Engineers Comments Regarding Surface Water Drainage

Application Reference:	BR/24/26/PL	Reviewer Reference:	ADC/EXT4
Planning Officer:	Simon Davis	Date of Review:	22/04/2026
Site Name:	Tesco Superstore Shripney Road Bognor Regis PO22 9ND		
Application Description:	Installation of single storey raised car park deck together with site alterations, car park reconfiguration, new access into car park, drainage alterations, creation of new drainage outfall, landscaping and other associated works.		
Assessment Number:	1 of 2

Drawing Number: **30268440-ARC-P01-XX-DR-LA-00004** Revision: **7**

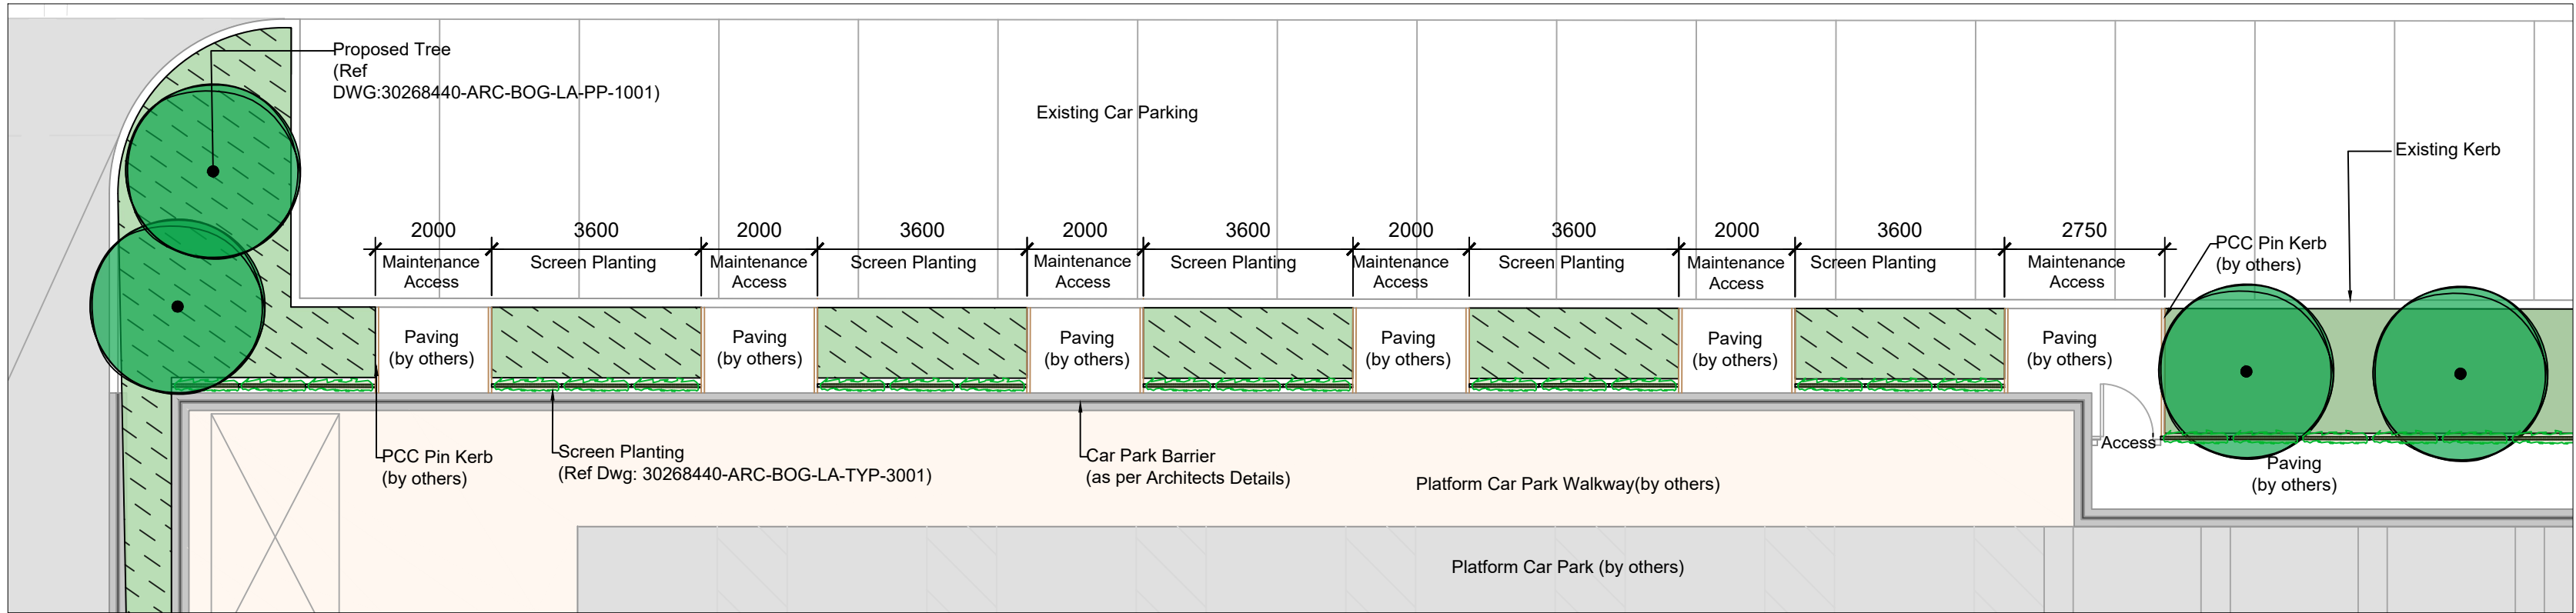
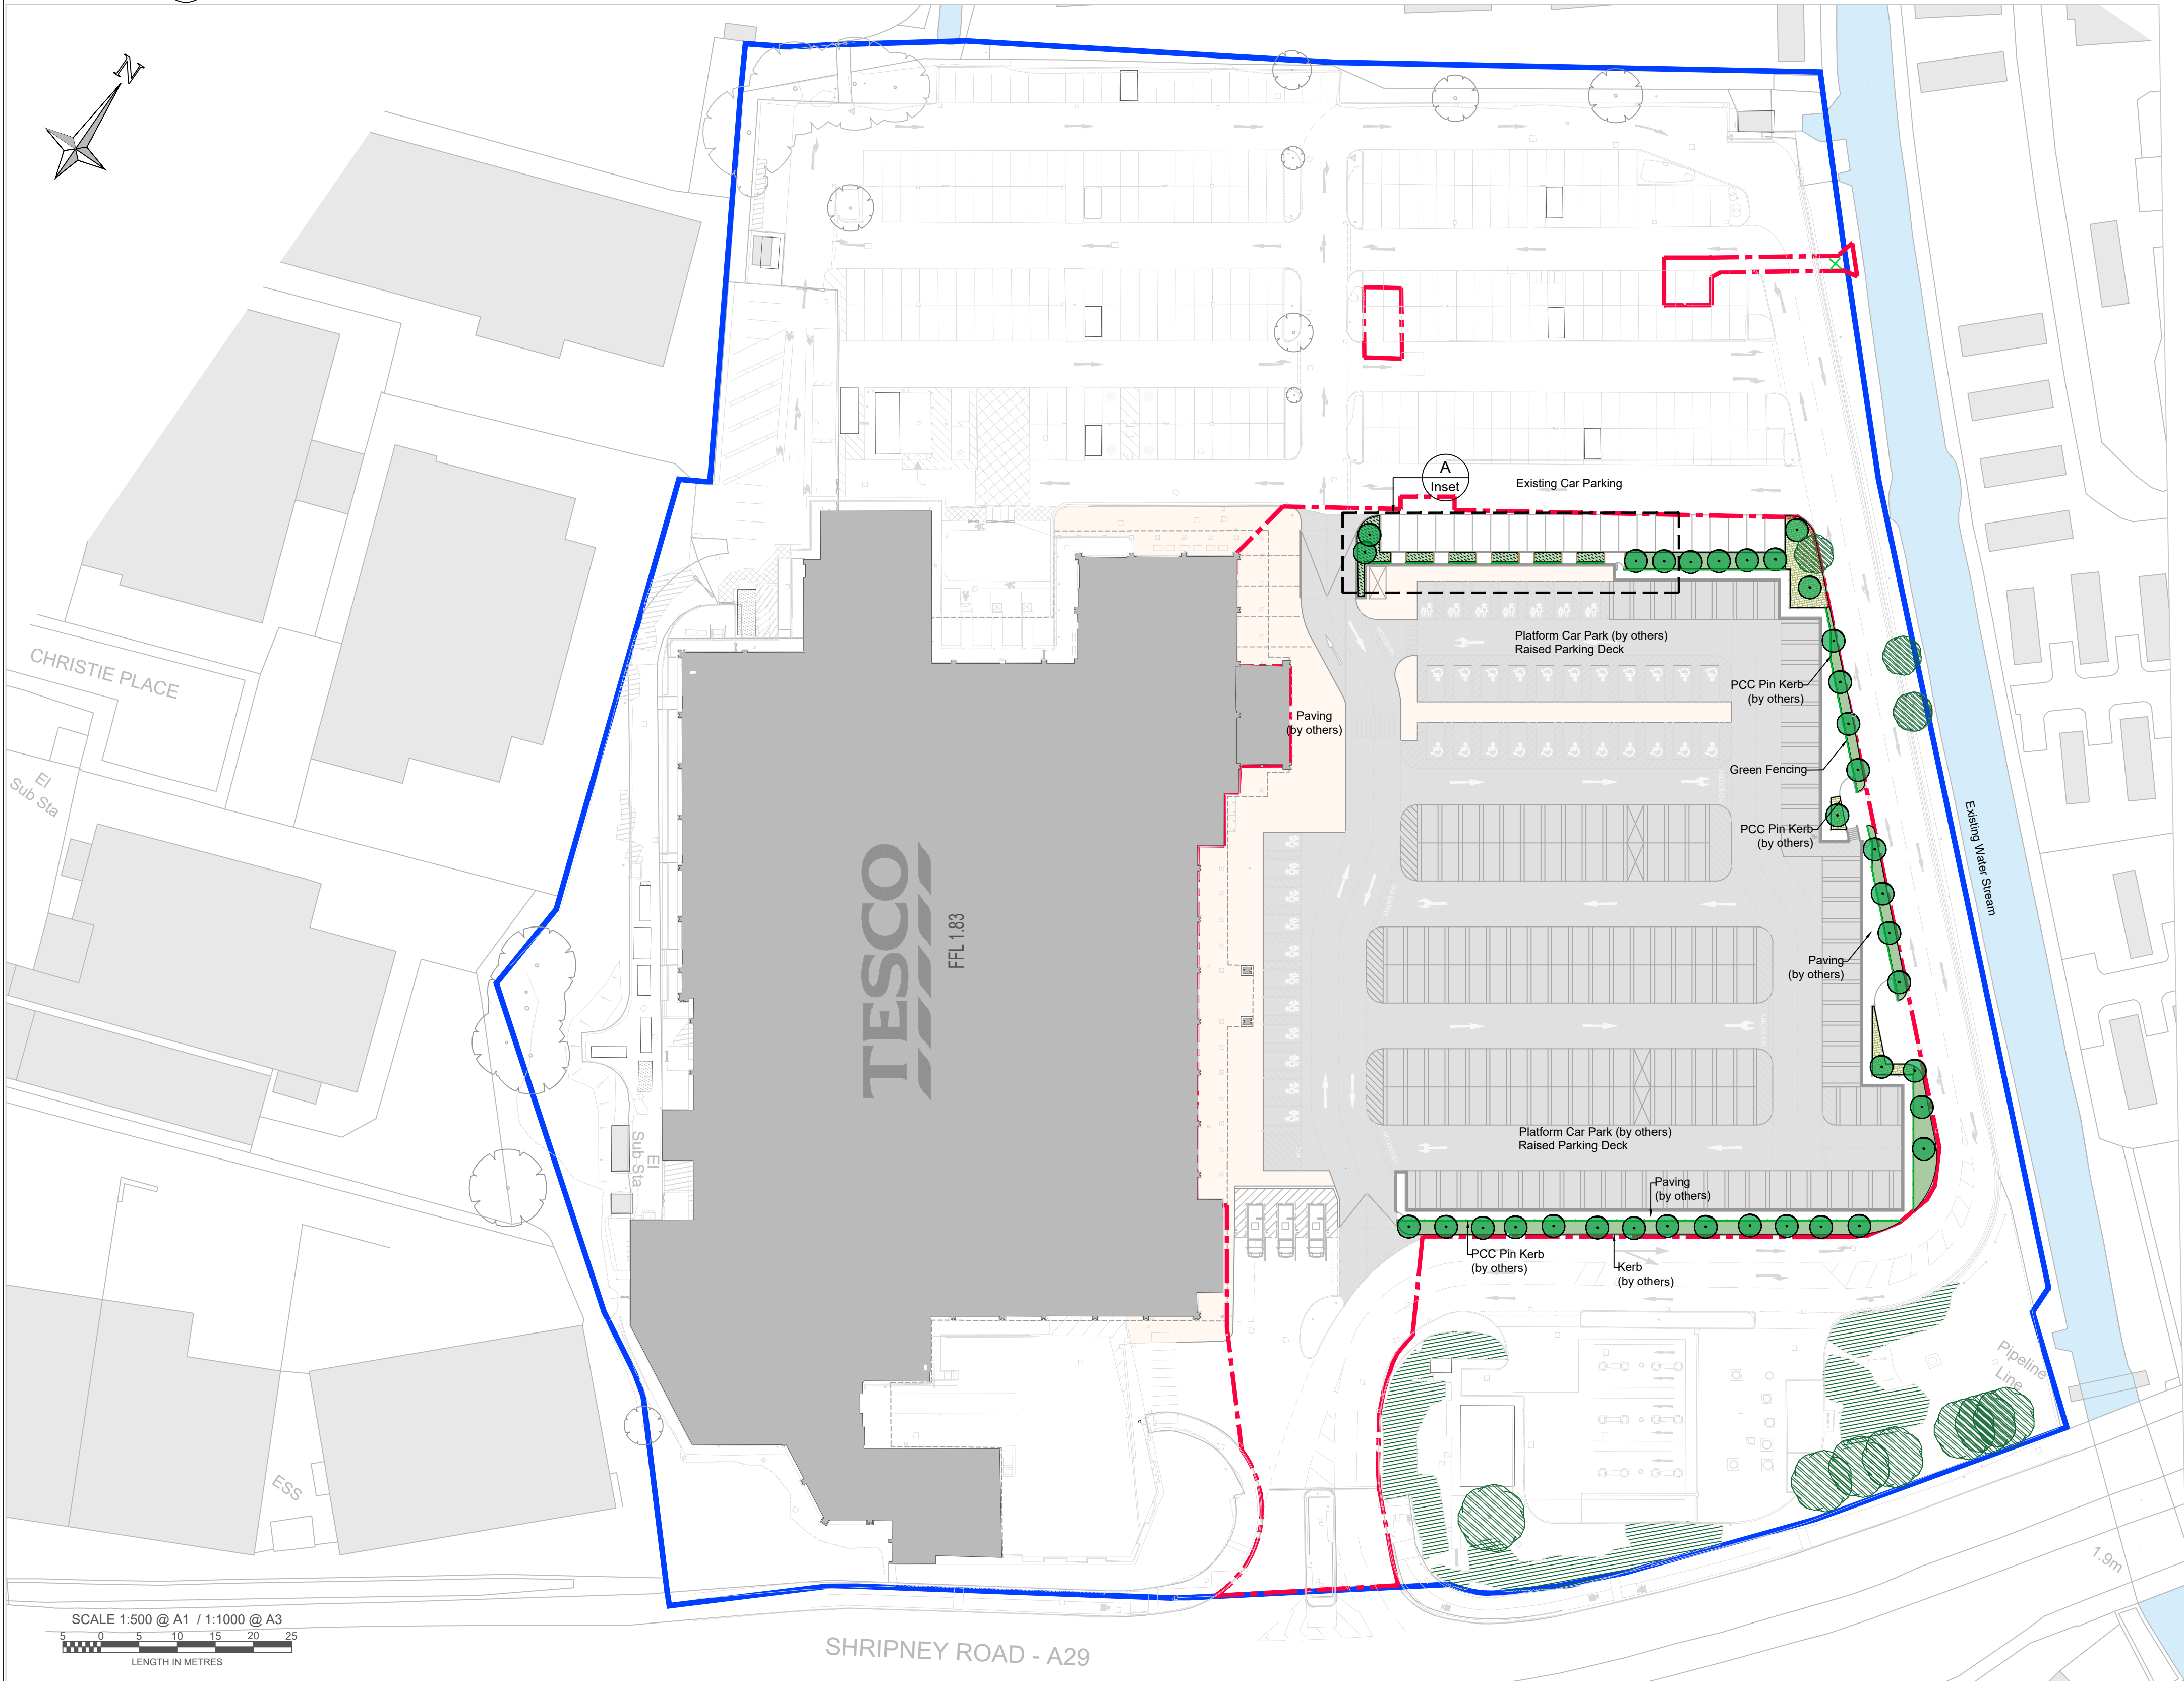
- 5.1. The proposed planting and soft landscaping presented in the Arcadis Flood Risk Assessment and mitigation proposals does not appear to be reflected in the Fairhurst Drainage Alteration plan. Clarification is required on what soft landscaping is proposed and whether central planted bioretention areas are being proposed per the Arcadis proposals.
